From: Paul Cann <Paul.Cann@arun.gov.uk>
Sent: 27 June 2022 13:21
To: Planning.Responses <Planning.Responses@arun.gov.uk>
Subject: RE: Planning Consultation on: Y/62/22/HH

Application No: Y/62/22/HH
Registered: 12th May 2022
Site Address: 27 Goodhew Close Yapton BN18 0JA
Grid Reference: 498370 103079
Description of Works: Erection of detached single storey annexe in rear garden.

Proposed Block Plan

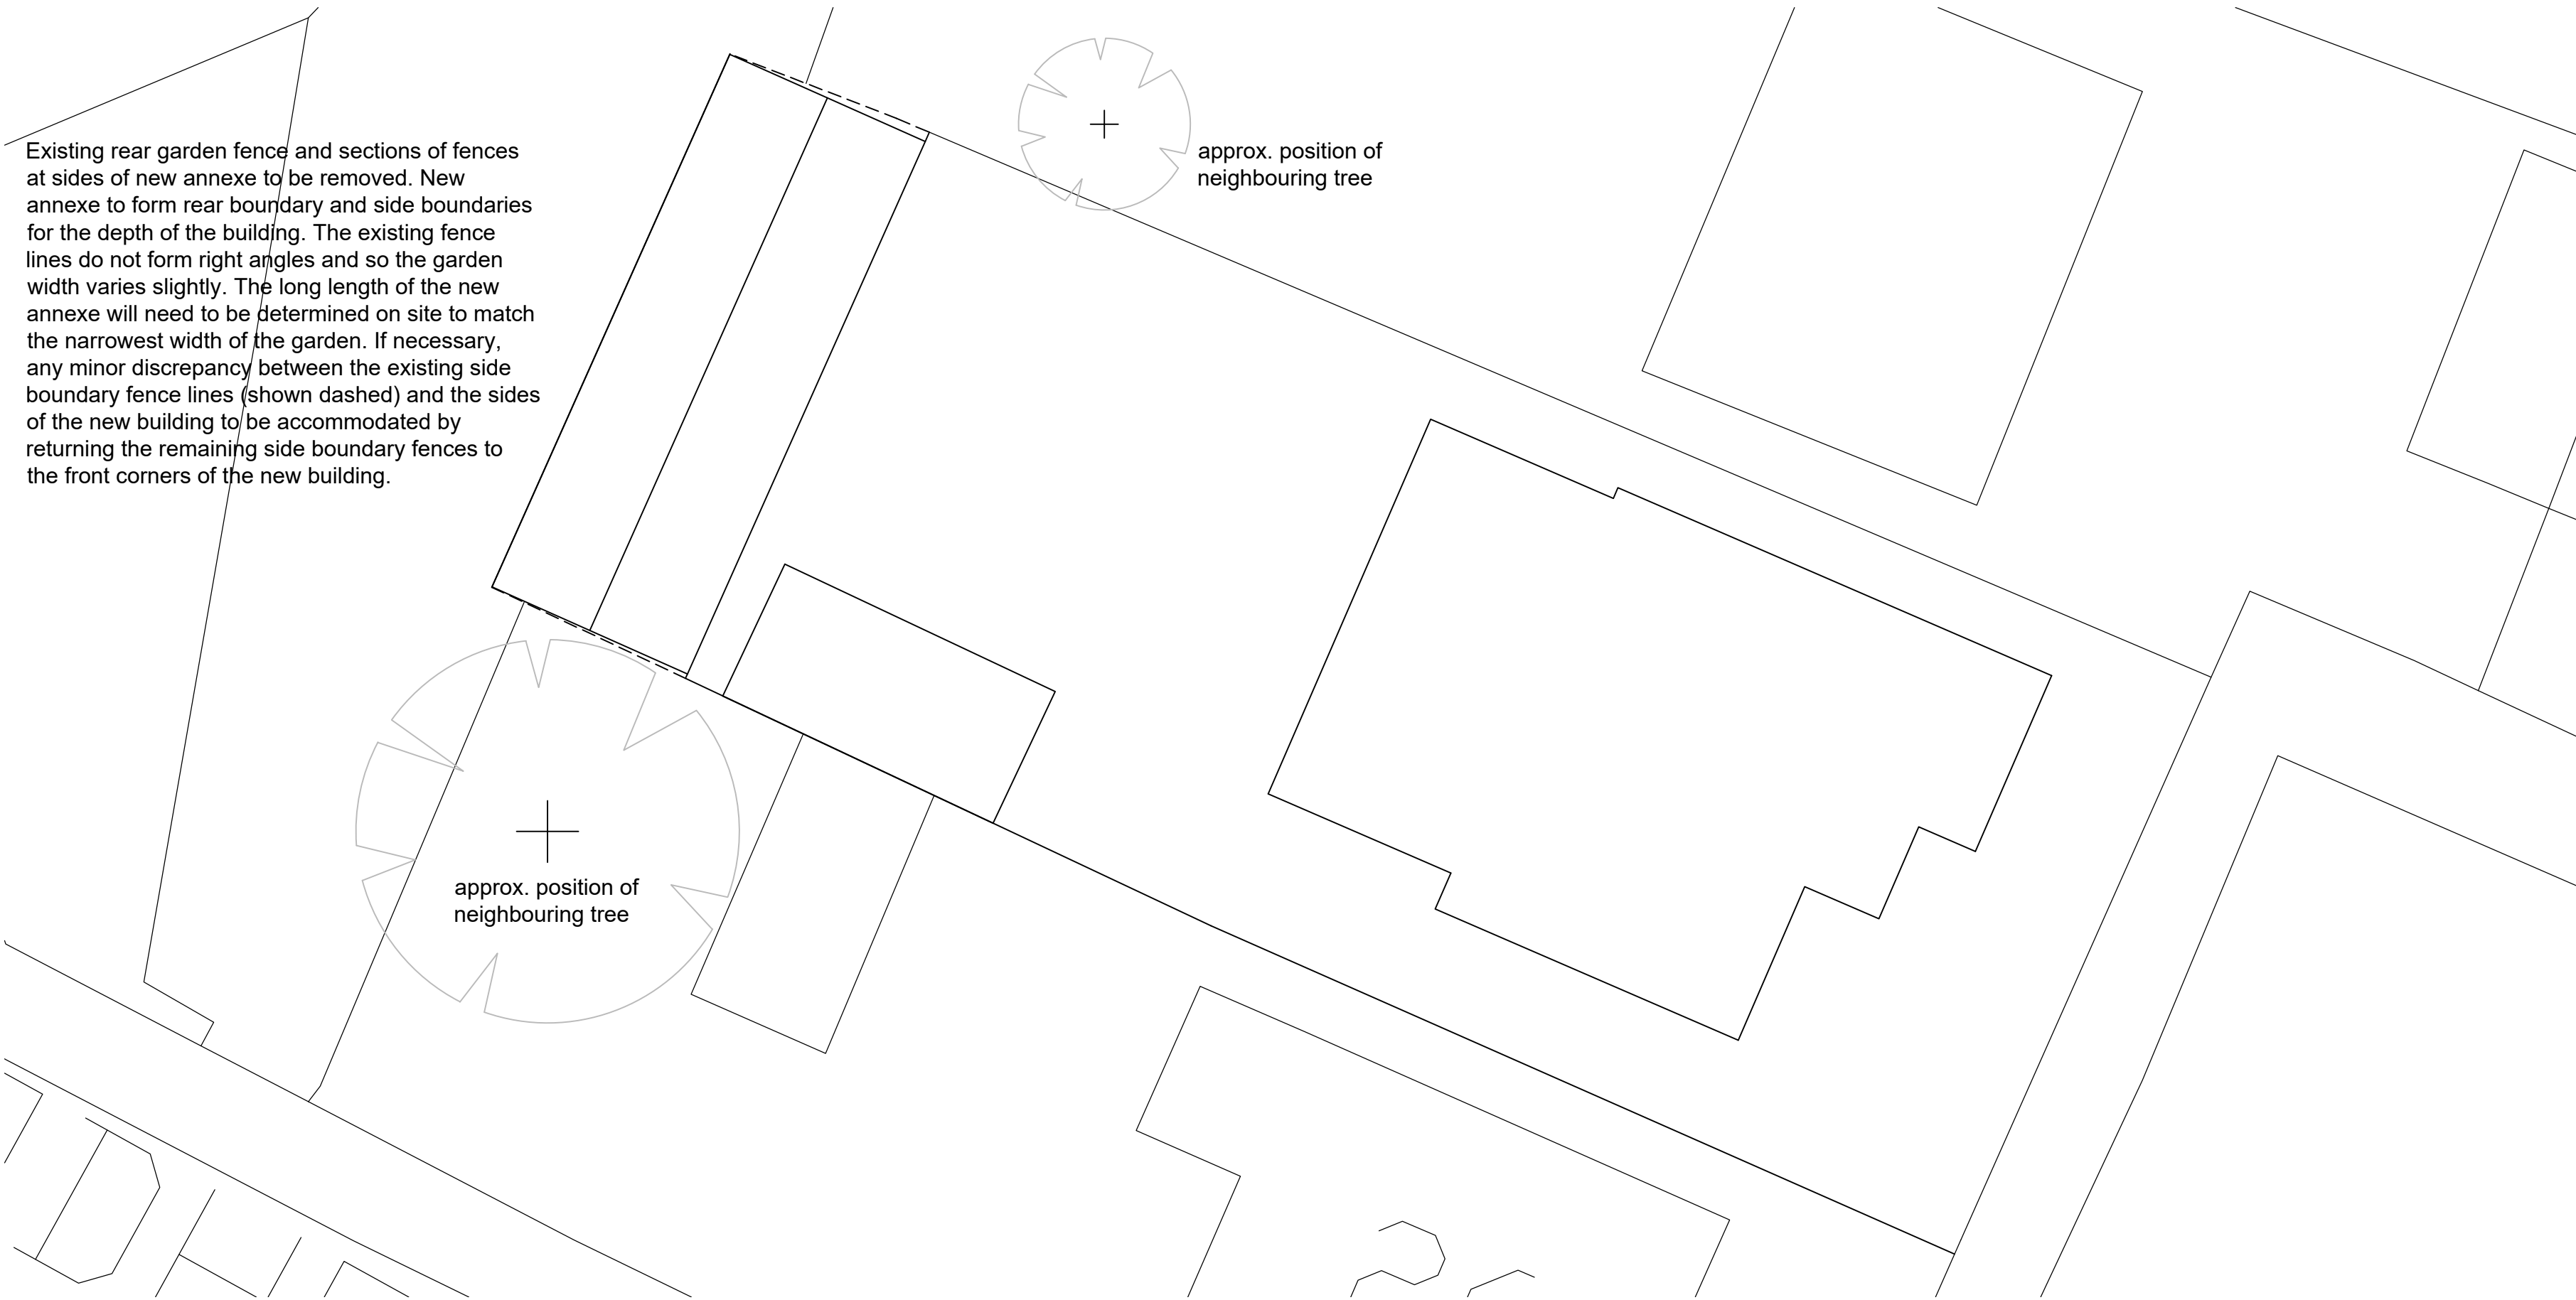
Unfortunately, the development proposals appear to leave insufficient space to accommodate infiltration devices/soakaways, since these structures must be kept at least 5 metres from any existing/proposed building. There may also be a soakaway serving the existing house which could be impacted and the same ruling applies.

To overcome my objection the applicant should complete winter groundwater monitoring and winter infiltration testing and complete calculations to assess the size of structures required. They will also need to provide sufficient room within the development layout to accommodate any proposed infiltration structure and also any existing soakaways, to ensure a minimum 5m clearance from buildings.

In respect to foul drainage, the applicant has indicated a proposed connection to an existing manhole, however, they will need to verify that this manhole forms part of the existing foul drainage system.
